SANDWELL METROPOLITAN BOROUGH COUNCIL	
Public Health	
FROM: Adult Social Care, Health and Wellbeing	TO: Regeneration and Economy
Officer: Sophie Morris	FAO: Anjan Dey
REF: MA046710	REF: DC/21/65575
TEL: 07425 619838	DATE: 17 th May 2021

TOWN & COUNTRY PLANNING ACT 1990: REPLY TO CONSULTATION - AIR QUALITY

Proposal: Proposed change of use of residential dwelling to nursery and associated parking

At: 131 Newton Road, Great Barr, B43 6BE

Drawing Title:  
**Proposed Parking**

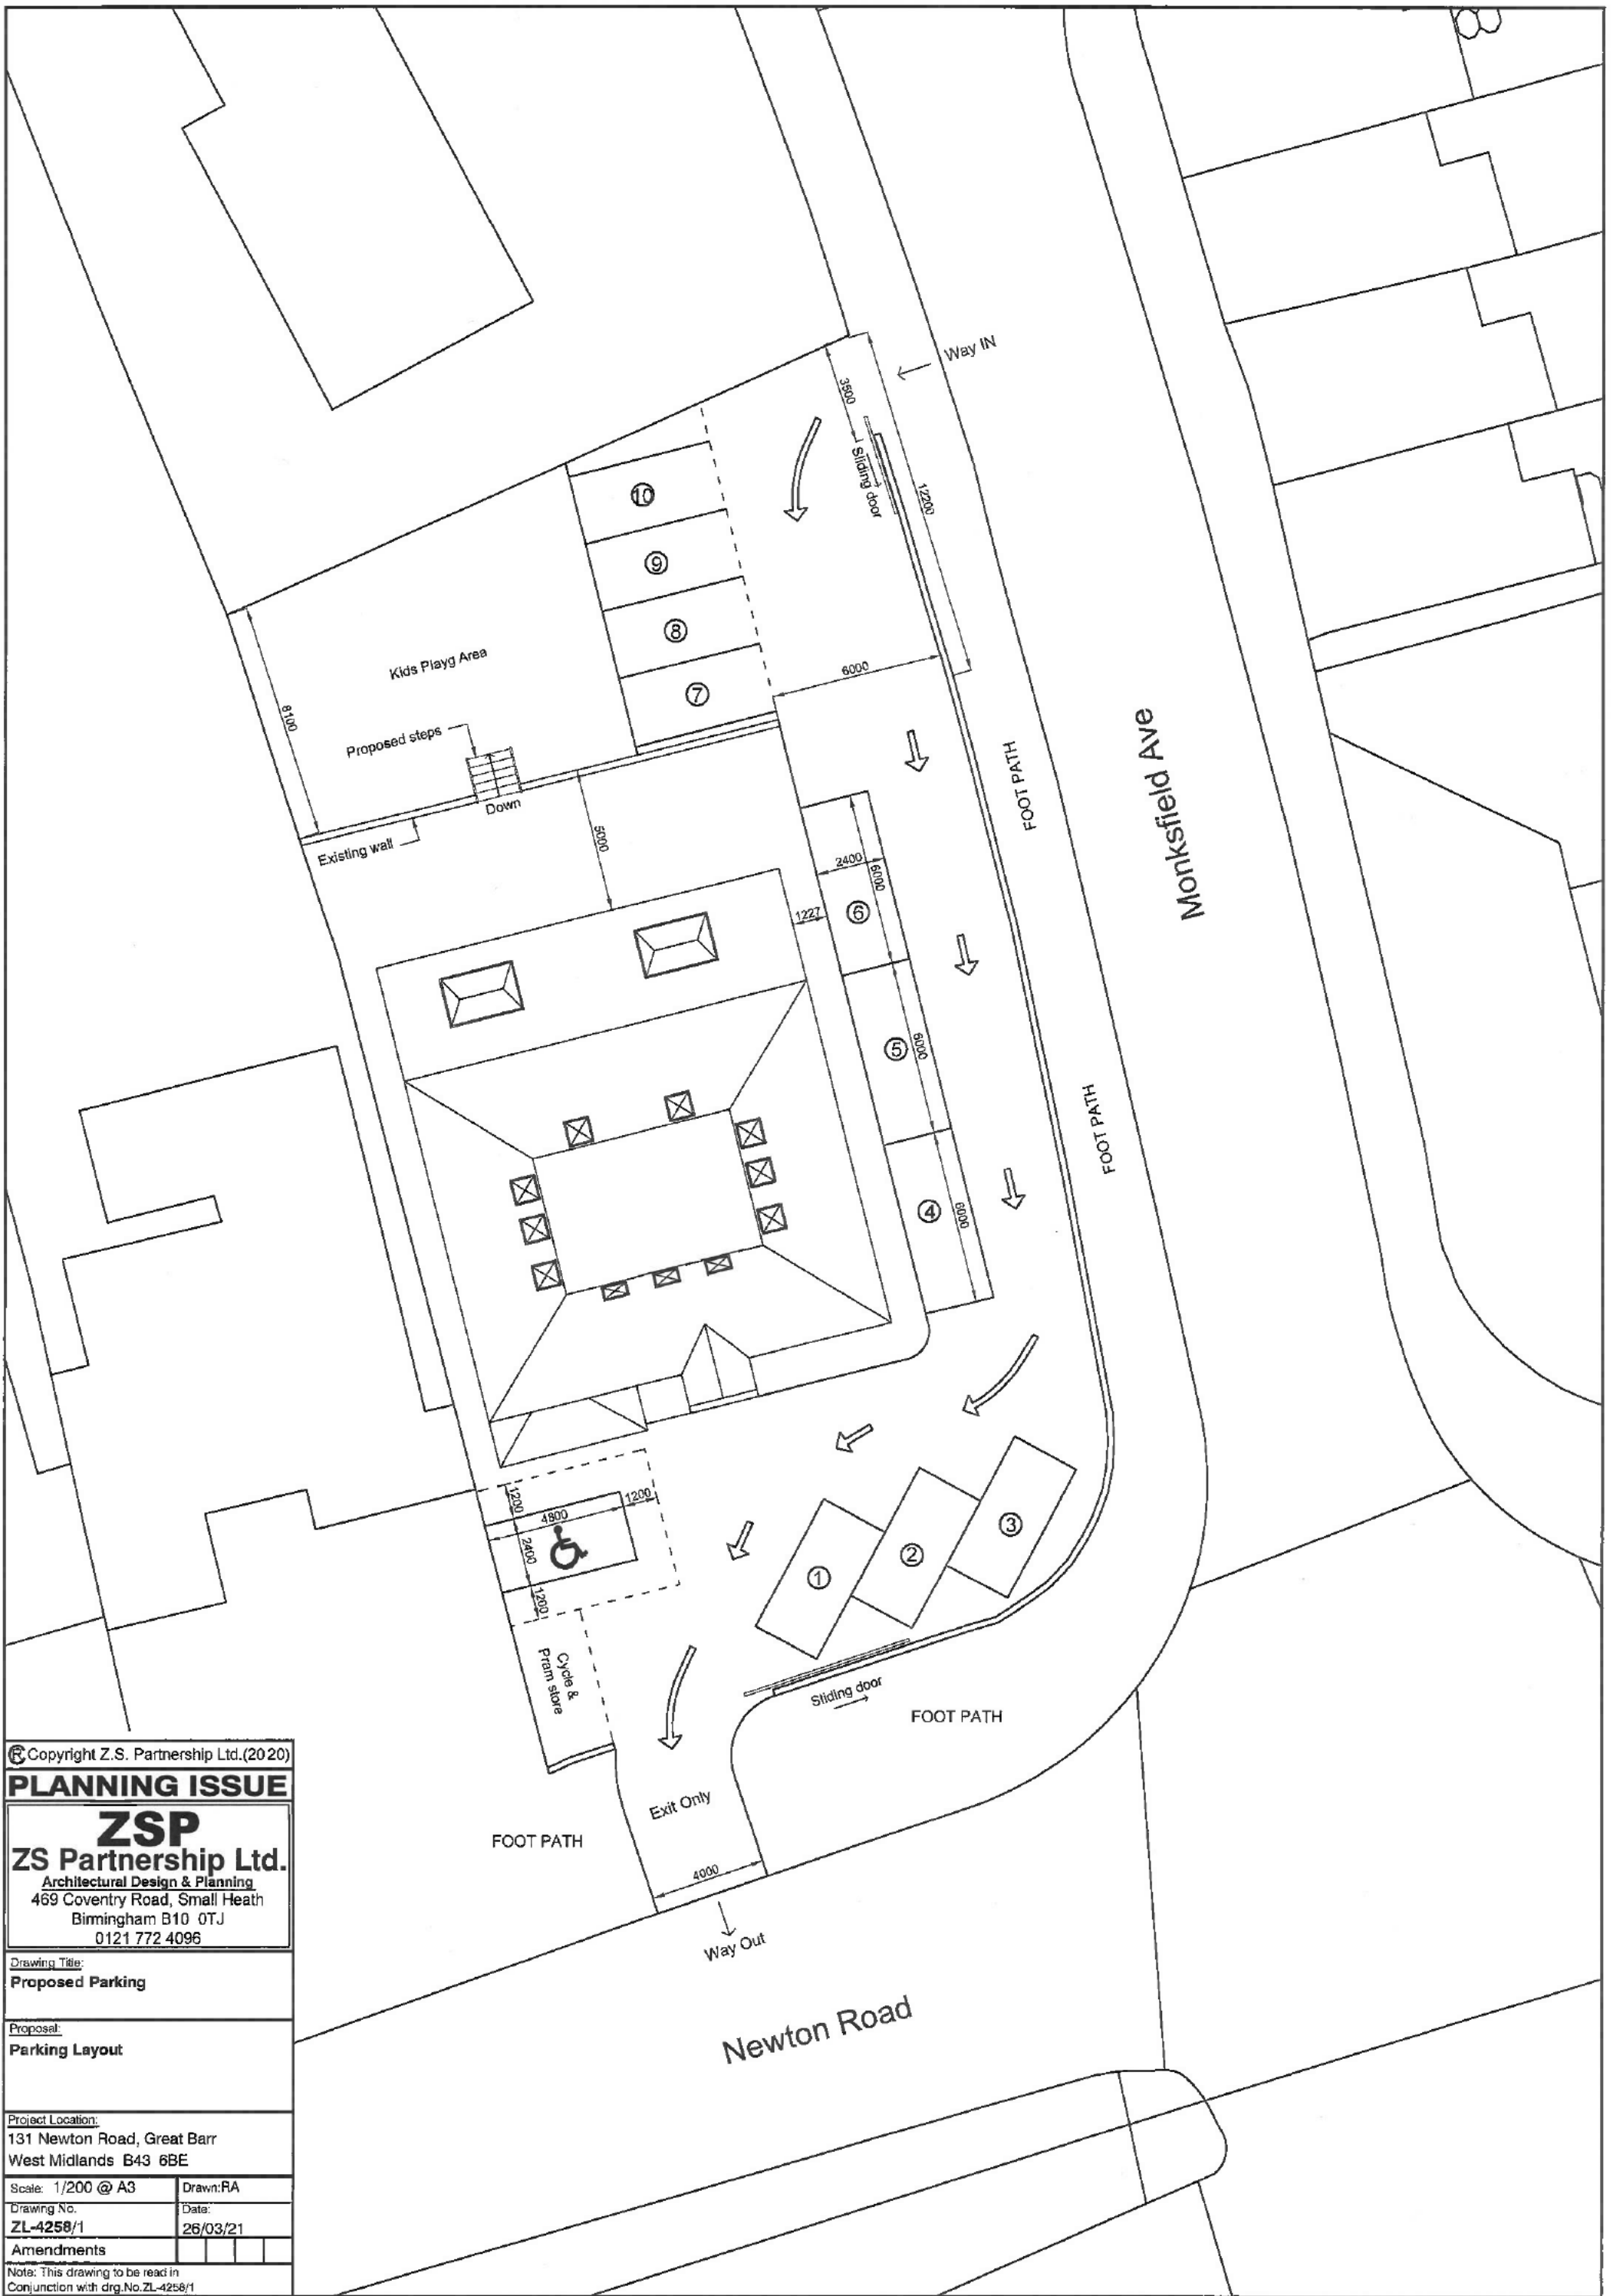
The proposed change of use includes 10 associated car parking spaces, and 1 disabled car parking space. 131 Newton Road is in close proximity to Air Quality Priority Zone 4 and the area has a history of poor air quality. I acknowledge the provision of a Transport Statement. It is recommended that the following conditions should therefore be attached to the planning permission.

1. a) No development shall commence until details of the electric vehicle charging points proposed are submitted to and approved in writing by the local planning authority.
- b) Prior to first occupation, the electric vehicle charging points shall be provided in accordance with the approved details and shall be maintained for the life of the development.

(As a minimum 1 EV charging points would be required but we would strongly encourage additional EV charging provision).
